Rezoning Transportation Analysis

Petition Number: 2020-200

Date	Description
12-28-2020	First Review (KP)
01-21-2021	Second Review (KP)
02-18-2021	Third Review (EL, KP)

RZ-1.0

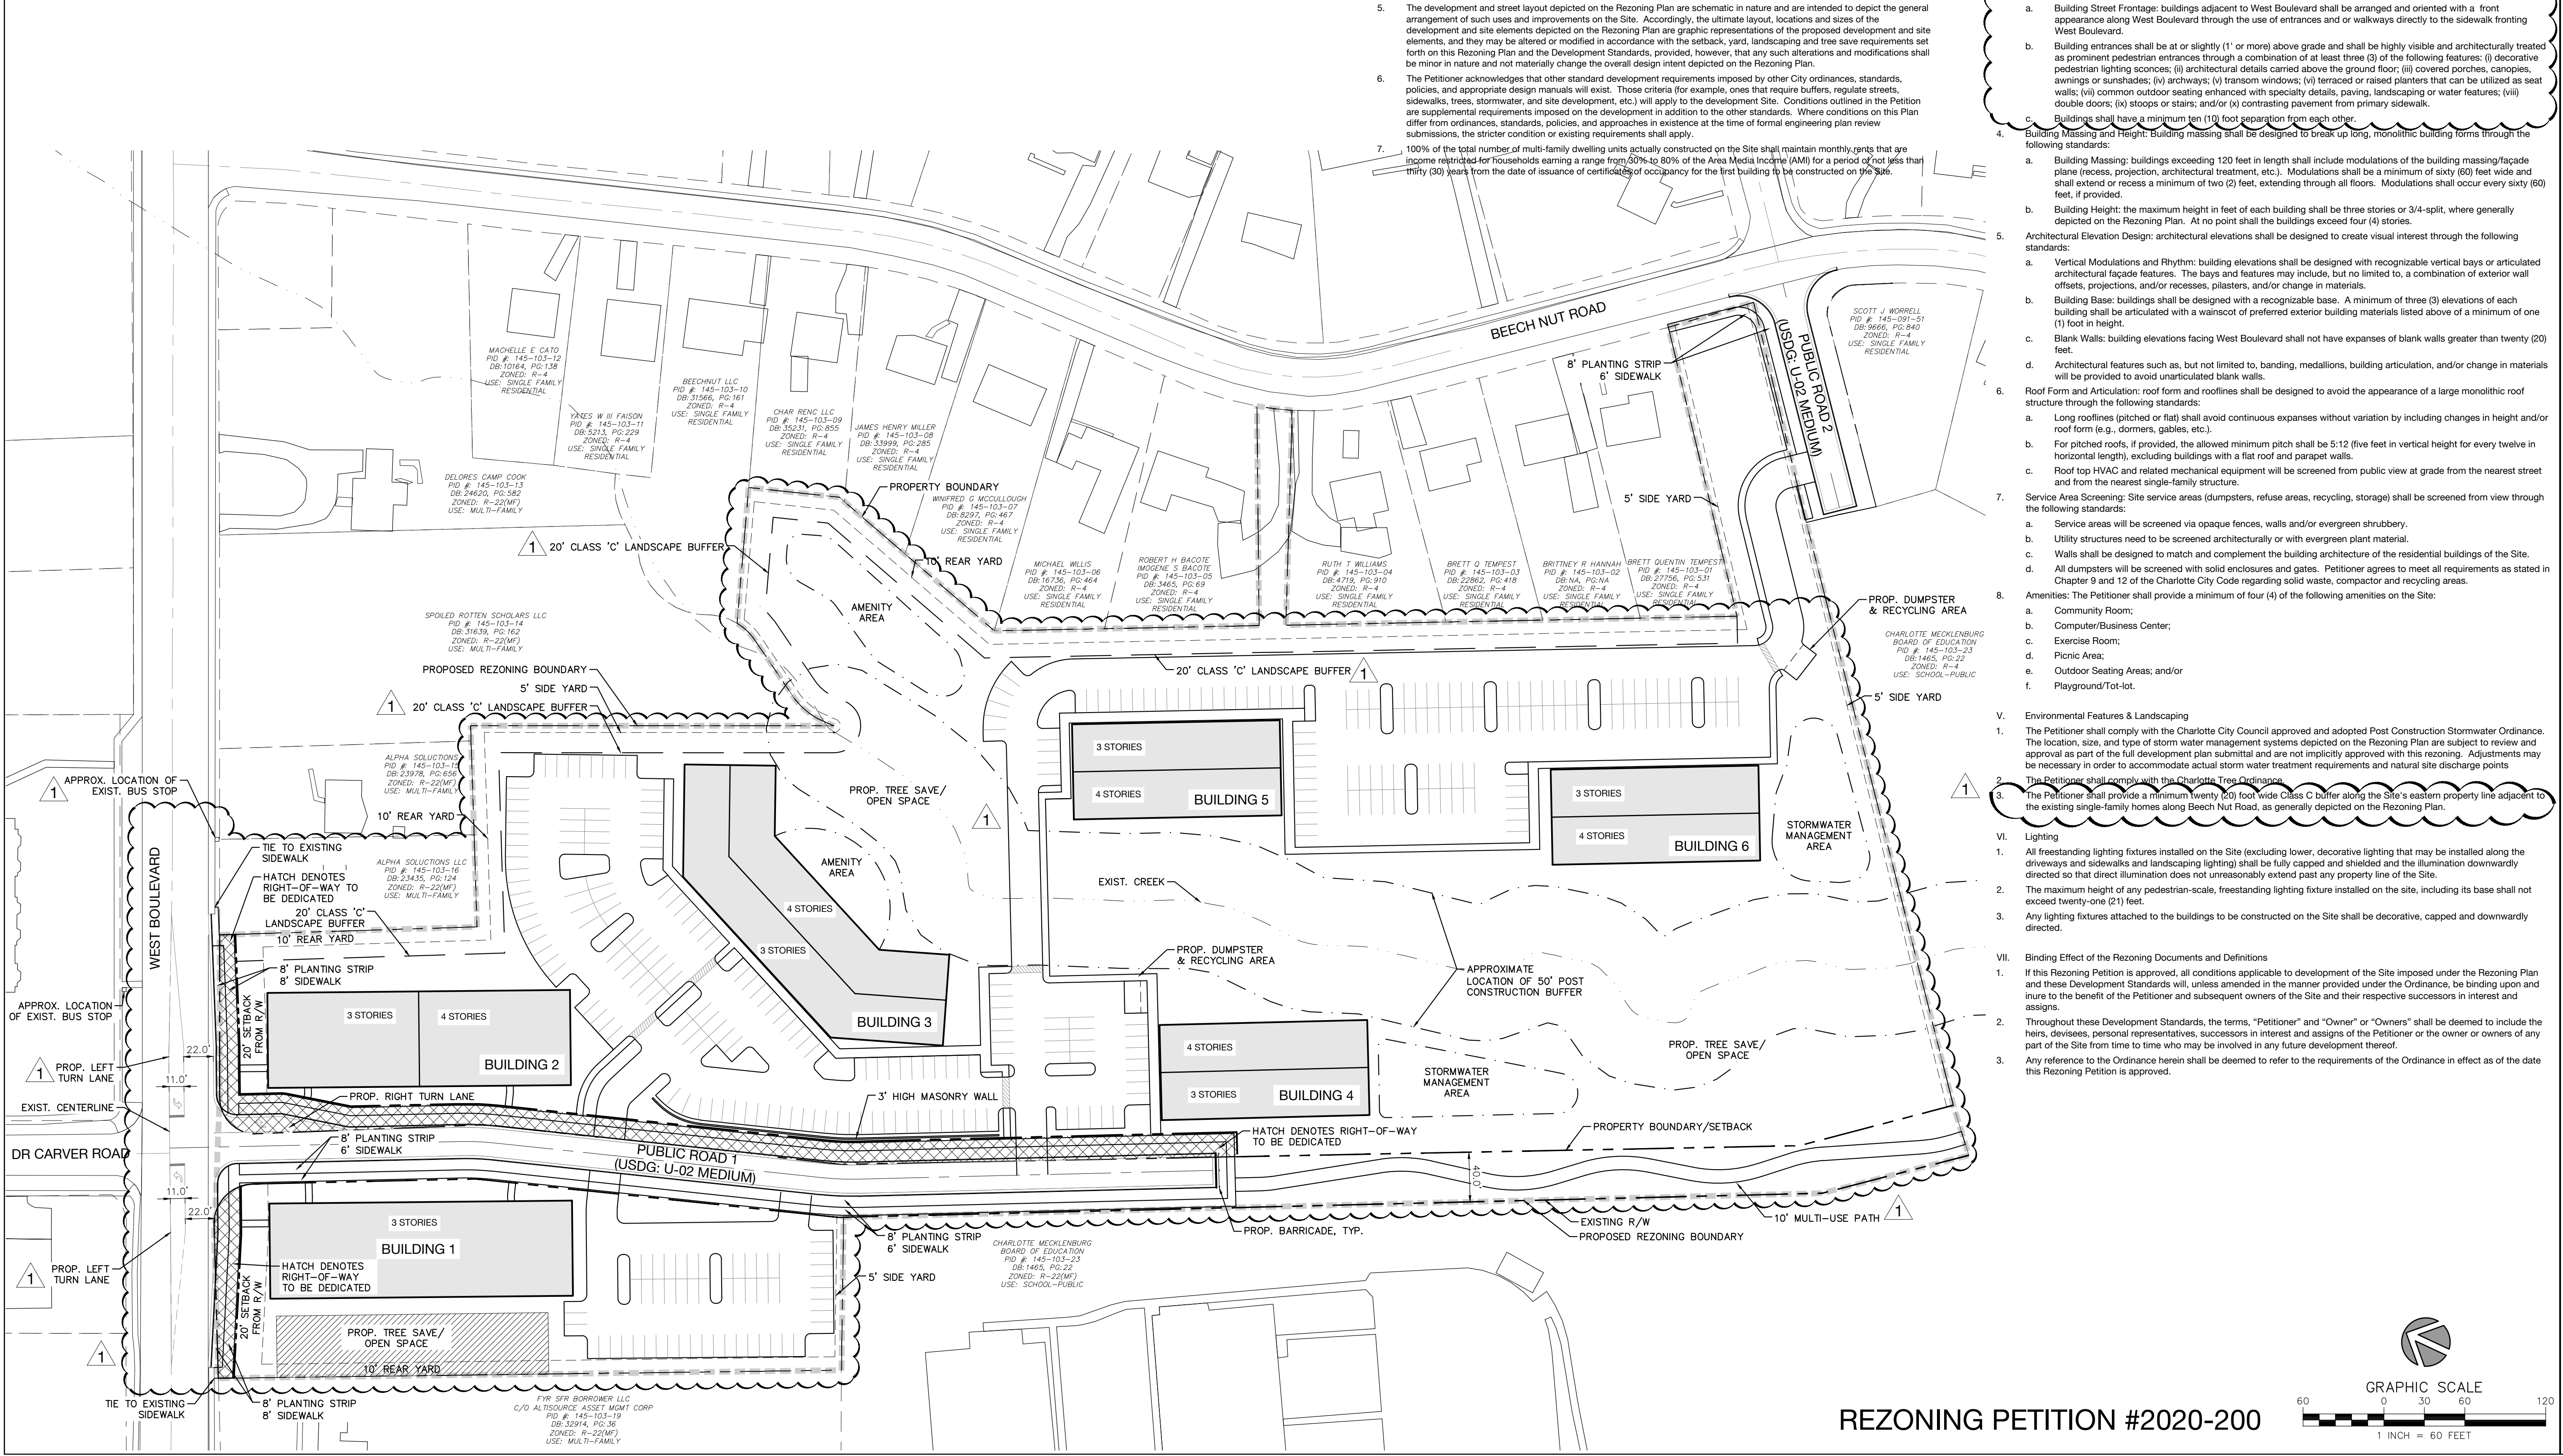
1. **Outstanding Comment (site plan dated 02-12-2021) Curblin**e:
 - a. **West Boulevard:** Relocate the existing curb and gutter to the future location at 38-feet from the road centerline to back of curb, to accommodate a future 4-lane Avenue road cross section with buffered/separated bike lanes and left-turn lanes.

Label and dimension the curb and gutter from the centerline for each road on the site plan.

3. **Outstanding Comment (site plan dated 02-12-2021) Right-of-way Dedication:**
 - a. **West Boulevard:** Revise site plan and conditional note(s) to commit to dedicate 56-feet of right-of-way from the road centerline, to provide 2-feet behind the proposed sidewalk.
 - b. **Paper Right-of-way:** Revise the site plan and conditional notes to dedicate 56-feet of total right-of-way, 28-feet of right-of-way from the paper right-of-way centerline.

Label and dimension the right-of-way from the centerline of each road on the site plan.

4. **Outstanding Comment (site plan dated 02-12-2021)** Revise site plan and conditional note(s) to commit to construct an 8-foot planting strip and 8-foot sidewalk on West Boulevard, as well as an 8-foot planting strip and 6-foot sidewalk on Proposed Public Roads 1 and 2, unless otherwise required

- Outstanding Comment (site plan dated 02-12-2021)** In accordance with the Charlotte BIKES Plan, revise the site plan and conditional notes by committing to the construction of an 8-foot buffered bike lane along the site's West Boulevard frontage. The site plan needs to label and dimension the buffered bike lane from the road centerline.

- Outstanding Comment (site plan dated 02-12-2021)** Revise the site plan and conditional notes by committing to the construction of two left-turn lanes, on West Boulevard, and providing left turning movements onto Dr. Carver Road and Proposed Public Road 1. Additionally, signal modifications will be required to accommodate the additional left-turn lanes and the addition of Public Road 1 as the fourth leg of the intersection. These improvements will be required to be built to NCDOT Standards.
Update to Comment (01-12-2021 Site Plan): A conditional note committing to the left-turn lanes and signal modifications needs to be included. Additionally, include a conditional note that commits to coordinating with NCDOT, during permitting, to determine storage lengths, tapers, and any other potential lane striping modifications.

- 9. **Outstanding comment (02/12/2021 Site Plan):** Revise the site plan and conditional notes by committing to coordinate with Charlotte-Mecklenburg Schools (CMS) to provide a pedestrian connection/access to the Irwin Creek Greenway. The ICG currently has a trailhead located within the adjacent property of the Berringer Academic Center.

10. **Outstanding Comment (site plan dated 02-12-2021):** Revise the site plan and conditional notes by committing to coordinate with CATS, during permitting, to make improvements to the existing bus stop on West Boulevard. The site plan needs to show the existing bus stop.

13. **Outstanding Comment (01-12-2021 site plan):** Revise the site plan and conditional notes to commit to restriping the existing crosswalk, the Dr. Carver/Public Road 1 and West Boulevard intersection, in addition to the turn-lane and signal improvements.

14. **New Comment (02/12/2021 Site Plan):** Please clearly indicate the limits of right-of-way abandonment. Will the entire access drive off of West Boulevard be private? I would recommend shading the areas of proposed abandonment
